2 December 2025

REF: WTJ24 -549

**RE: AMENDMENT TO SSD-80018208 – PROPOSED DATA CENTRE
PROPERTY AT 6-8 JULIUS AVENUE, NORTH RYDE (LOT 89 DP1082131)**

Client	ISPT
Project	JULIUS AVENUE DATA CENTRE 6-8 JULIUS AVENUE
Scale	As Indicated
Drawn By	AD
Checked By	AD
Approved By	AD
Job Number	240089
Scale Bar	0 1 2 3 5 10m
Project Scale	1:200
Drawing Title	BUILDING ELEVATIONS 01
Drawing Number	150001
Issue	2

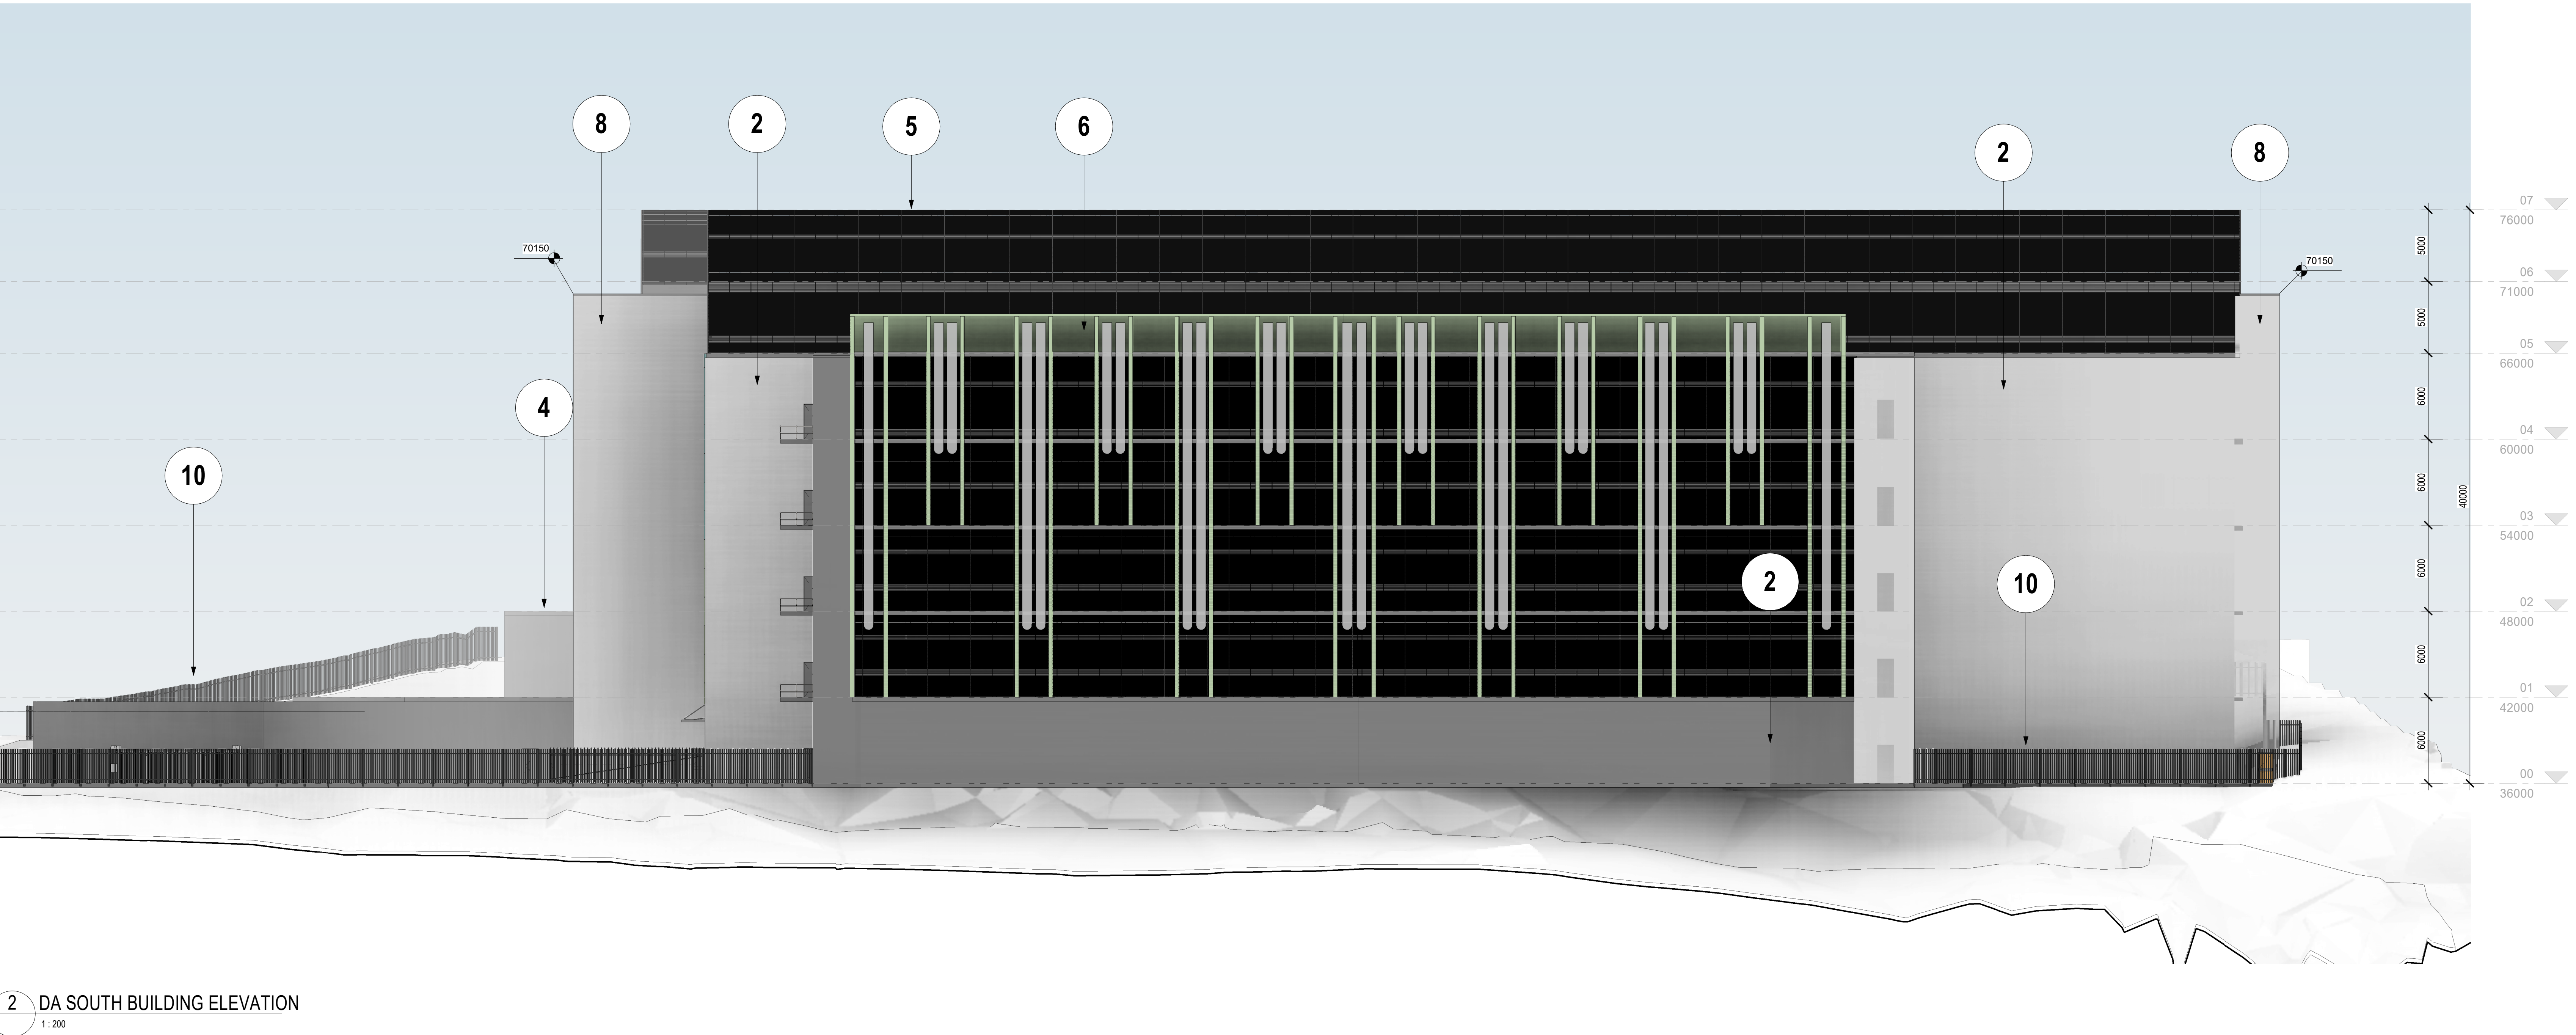
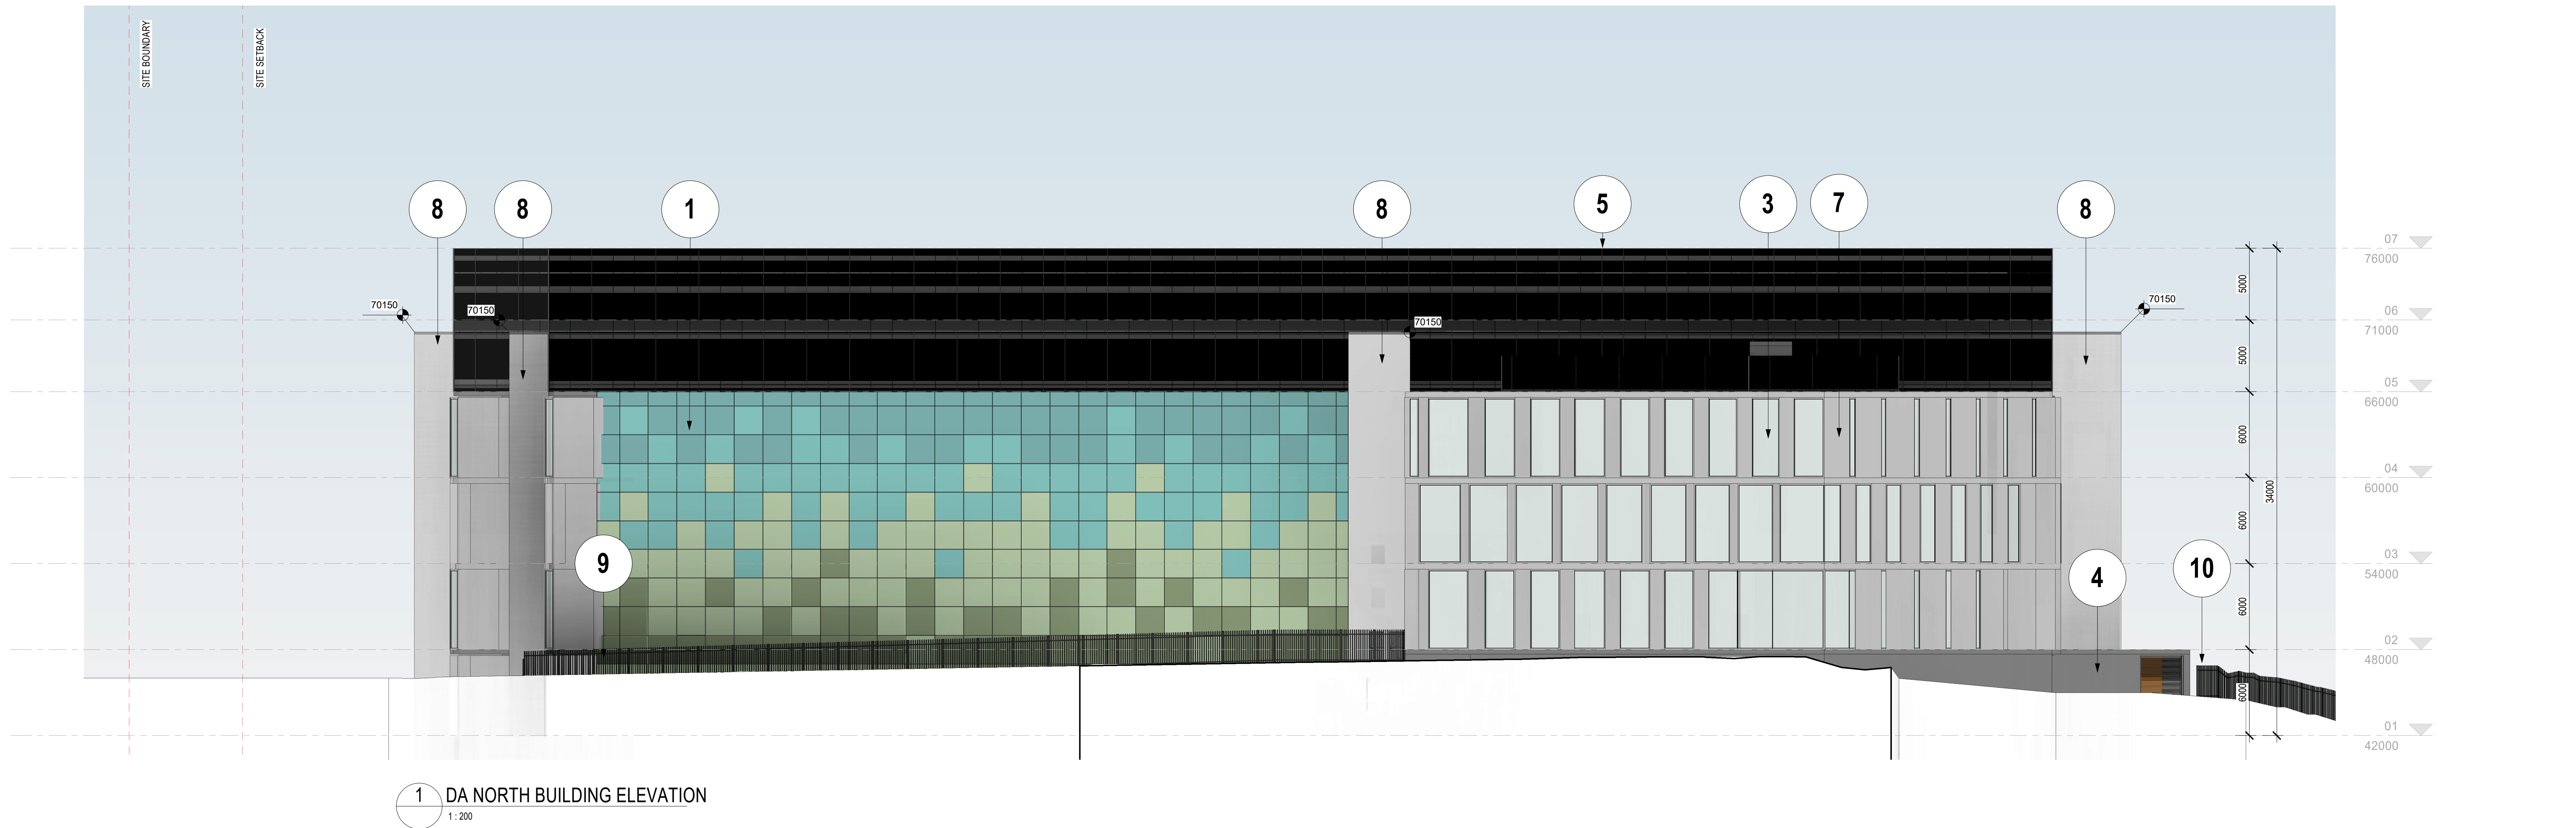
In response to commentary from City of Ryde, a request for additional street activation was provided within their submission. As a result, changes to the proposed building have been undertaken to better integrate with the Julius Avenue frontage of the subject site. Additionally, a revised façade materiality has been provided to negate previous reflectivity concerns. Further, setbacks to the north, east and west elevations have been increased to reduce the prominence of the building from Julius Avenue.
